October 21, 2025

Mike Badin
Black Sheep Construction, LLC
350 Raleigh Street
Holly Springs, North Carolina 27540

I have reviewed the Badin residence plan being constructed at 164 Horse Path Lane in Holly Springs, North Carolina as well as the pictures you have provided to address new footings installed at each end of the 18' garage door. The pictures include images of footing excavations, reinforcement (where required), and dimensions. The original plan was designed by Triangle Residential Designs Inc. and the engineering was sealed on October 9, 2024. All new construction shall conform to the 2018 North Carolina Residential Code (2018 NCRC), plus all local codes and regulations. All relative directions are noted as if one were facing the front elevation as noted on the architectural drawings. Analysis revealed the following:

FOUNDATION PLAN
S-1
SHEET 1 OF 4

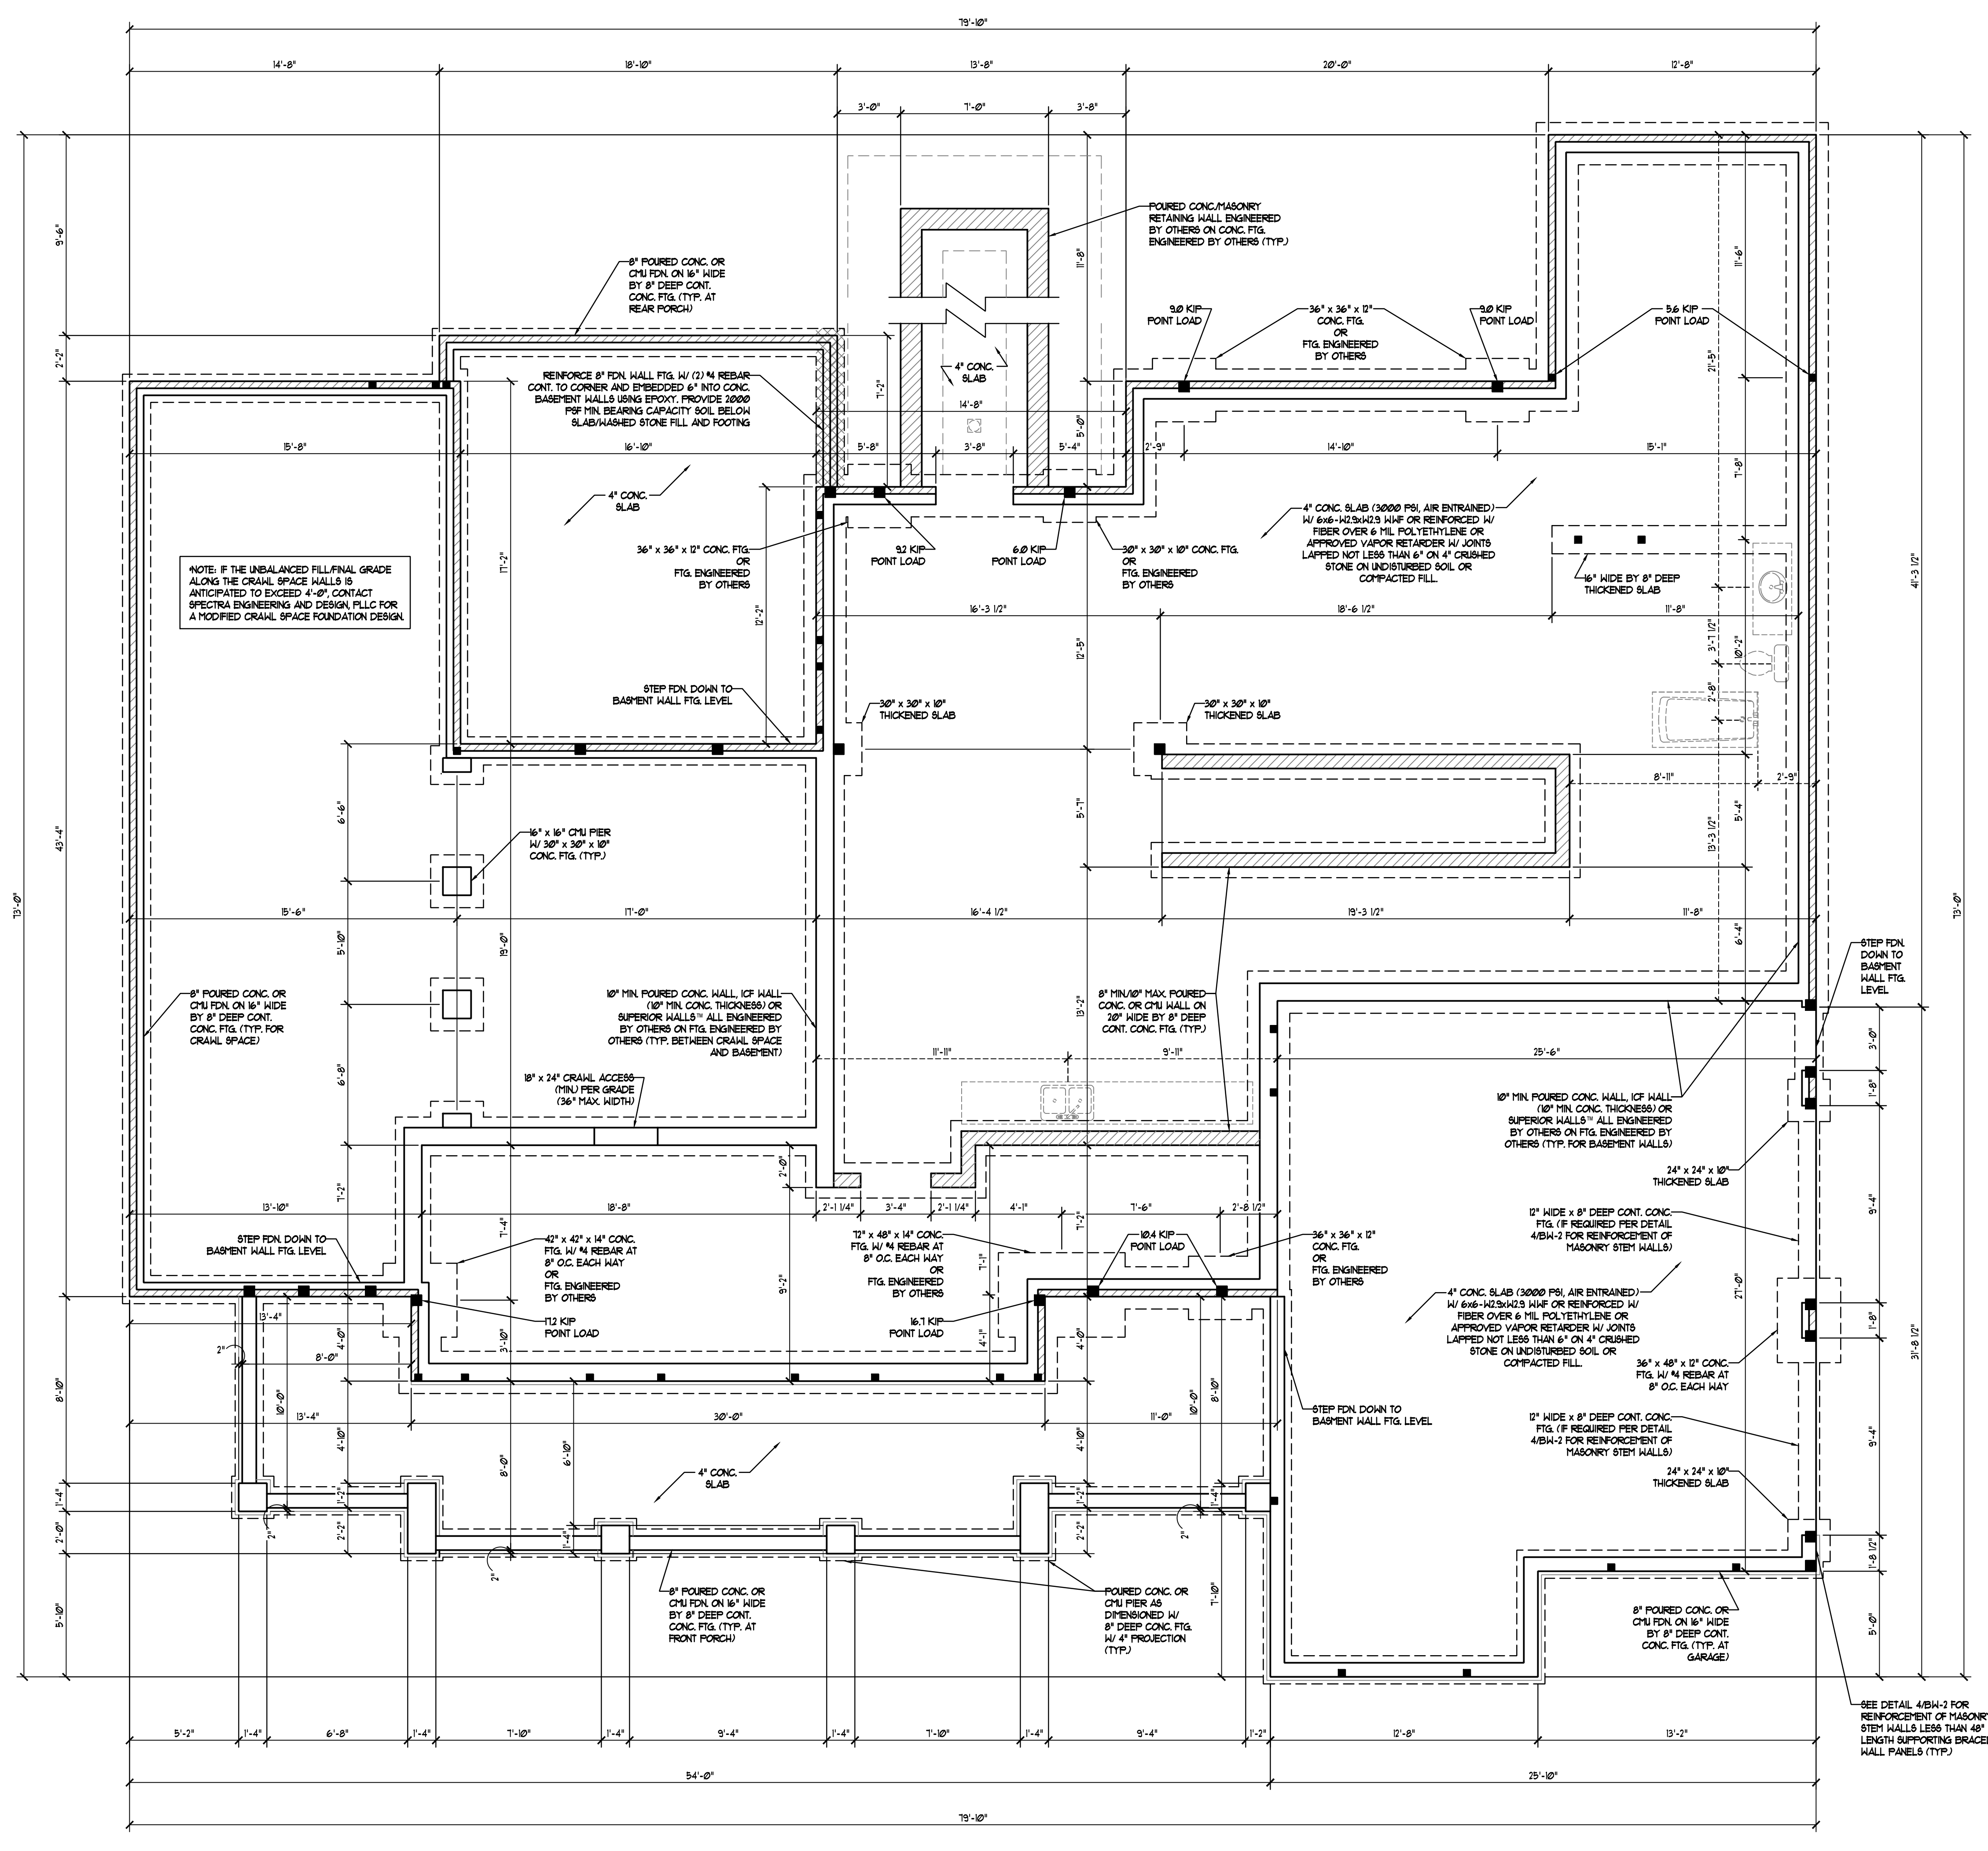
As per our conversation and the pictures, an approximately 38" wide by 12" deep concrete footing was installed extending from the front right corner of the garage to approximately 24" beyond the front end of the 18' garage door opening. The footing is reinforced with #4 rebar at 8" o.c. in each direction, with the reinforcement parallel to the opening embedded approximately 6" into the existing footing at the front right corner of the garage using epoxy. Additionally, an approximately 32" wide (minimum) by 12" deep concrete footing was installed extending from approximately 48" in front of the rear end of the 18' garage door opening to the rear right corner of the garage. No additional modifications are required.

The alternate configuration(s) listed above will provide the required support for all applied loads. This document is intended to describe alternate configuration(s) only and is not intended to relieve the Code Enforcement Official of the responsibility to inspect and field verify the alternate configuration(s) conform to this letter and the NCRC. The structural engineer is not responsible for, and will not have control of, construction means, methods, techniques, sequences or procedures, or safety precautions and programs in connection with the construction work.
